Current Zoning: N1-B (neighborhood 1-B)  
Proposed Zoning: R-8MF(CD) (single family residential, conditional)

Approximately 15.93 acres located on the west side of Milhaven Lane, south of Juniper Drive, and east of Interstate 77.

The petition proposes a residential community containing a maximum of 90 single-family attached dwelling units.

MASTER PLAN
REZONING PETITION #2022-218
MILHAVEN LANE SITE
 CITY OF CHARLOTTE, NC
 MATTAMY HOMES

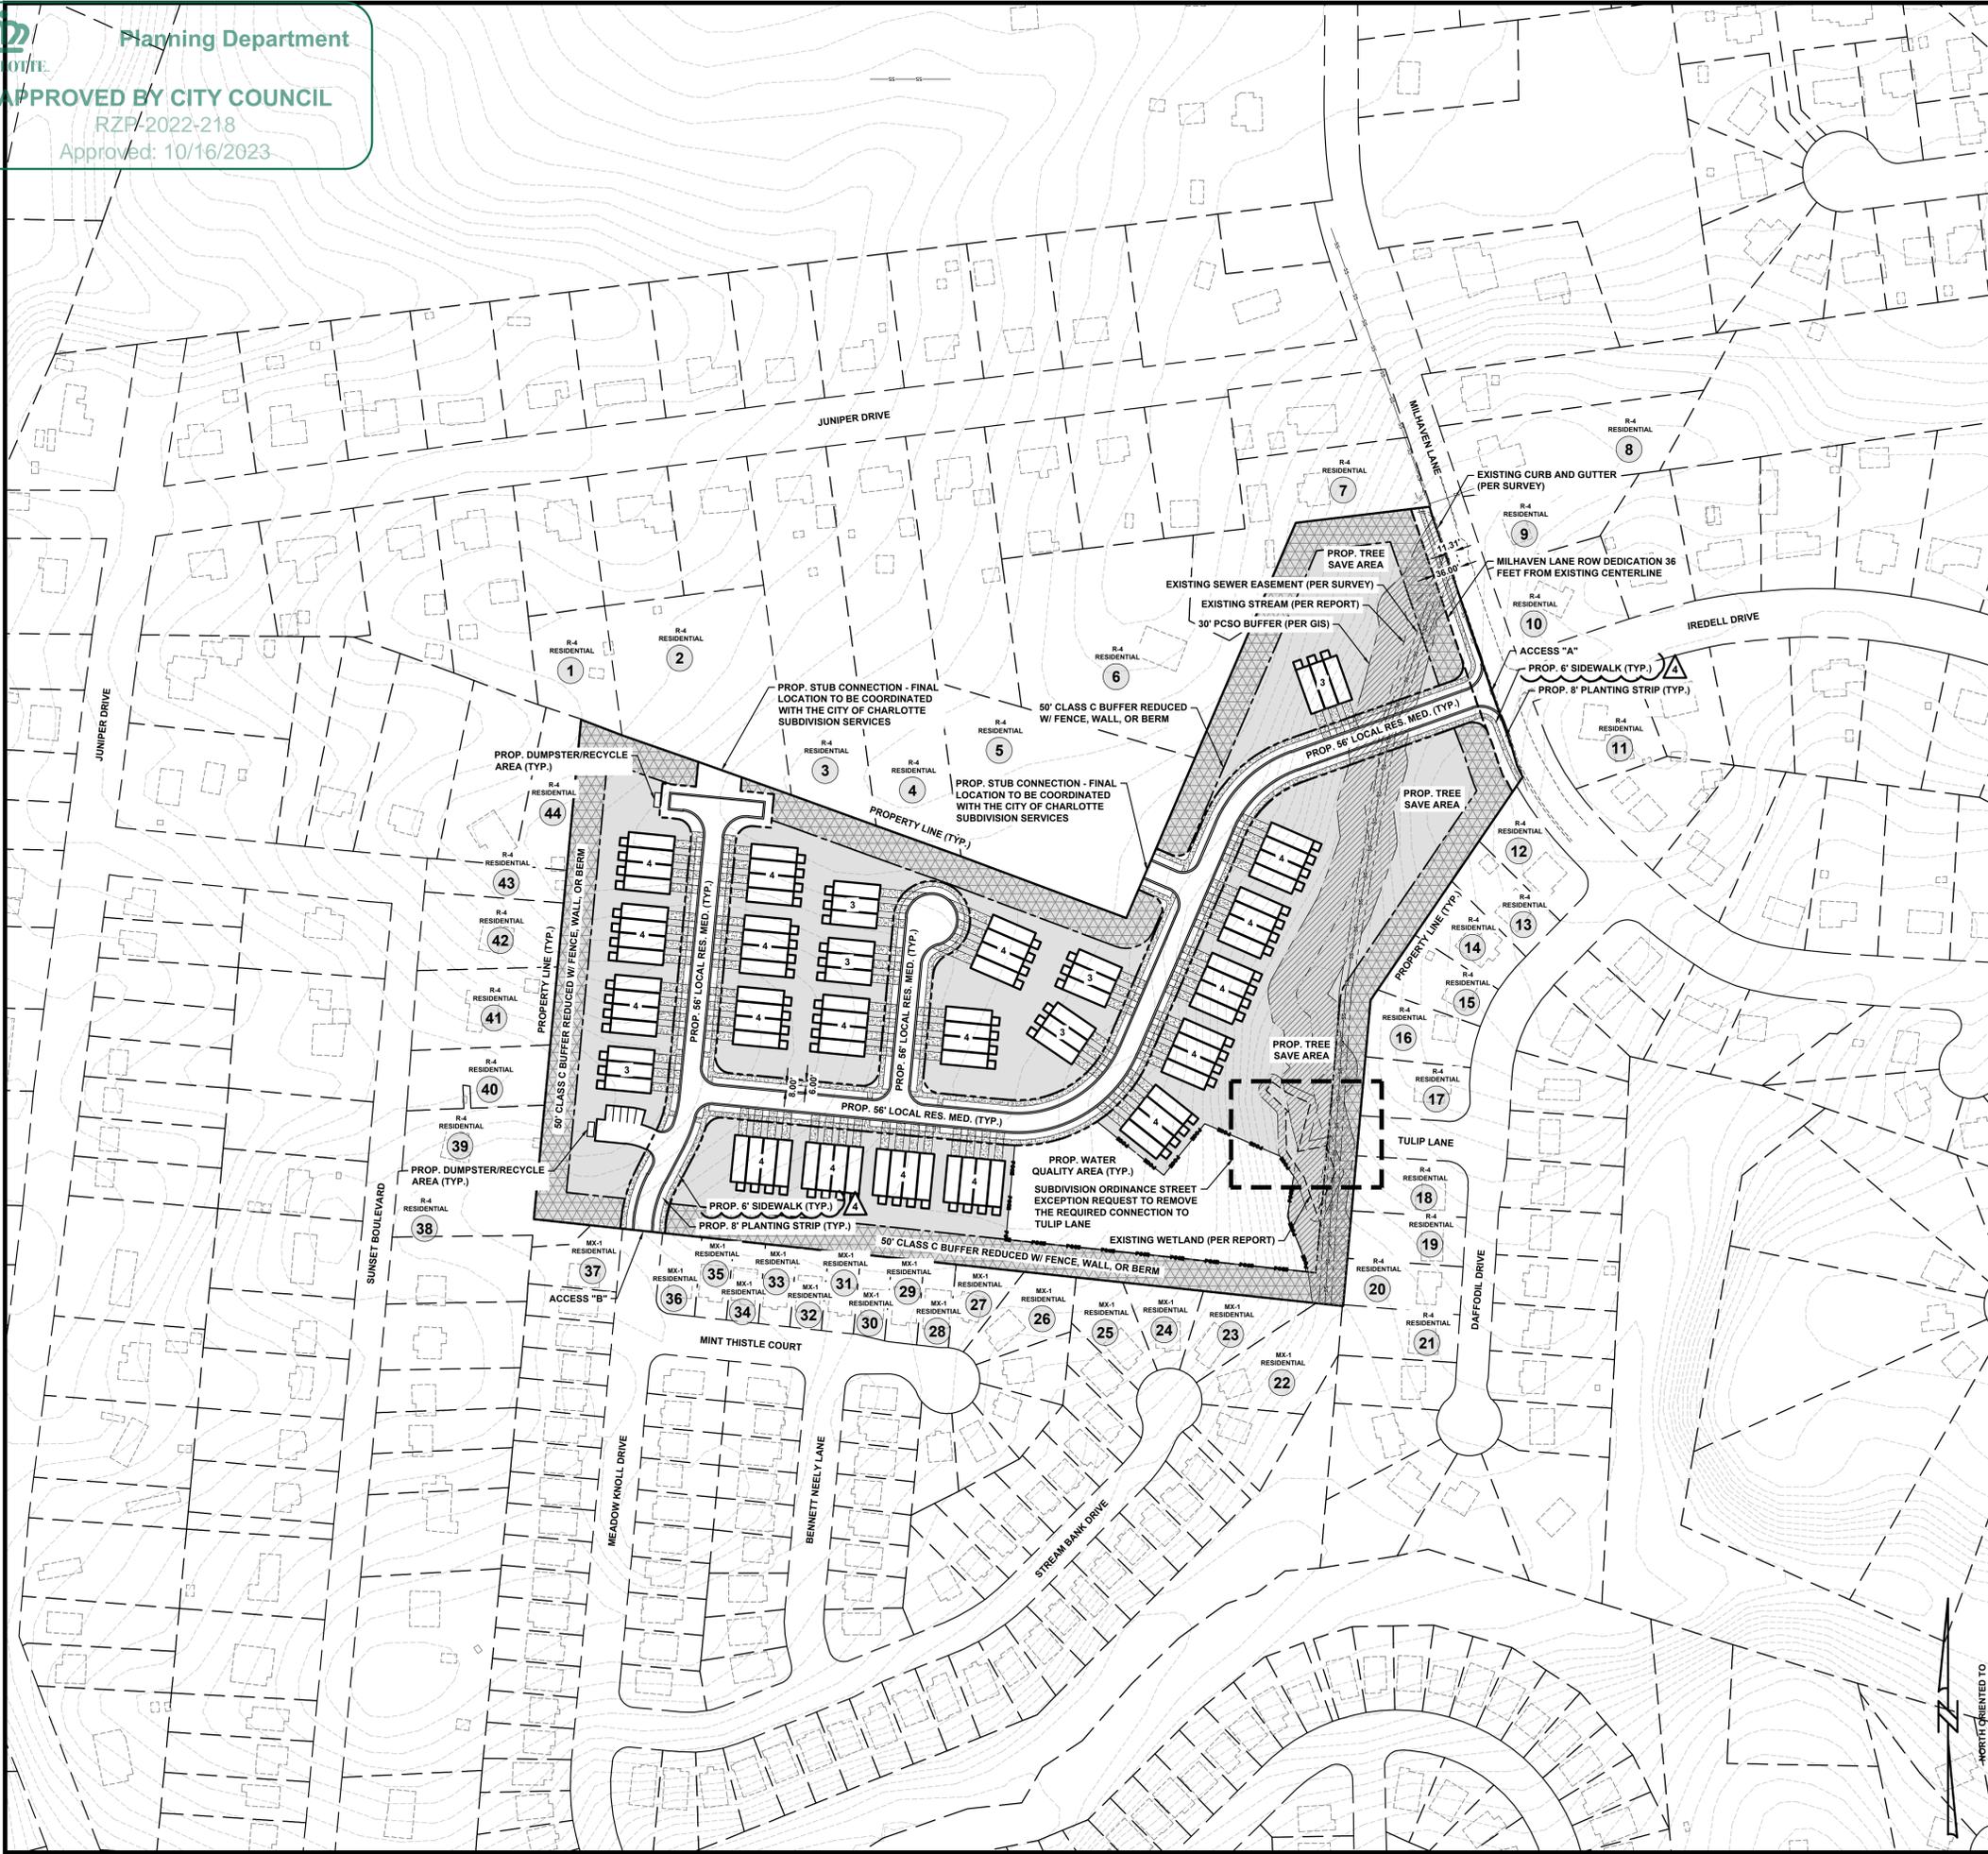
1. ~~Label and dimension 8-foot planting strip and 5-foot sidewalk along internal public streets.~~ Addressed
2. ~~Revise notes to say transportation improvements will be approved and constructed before the site's first building CO instead of 25th CO.~~ Addressed
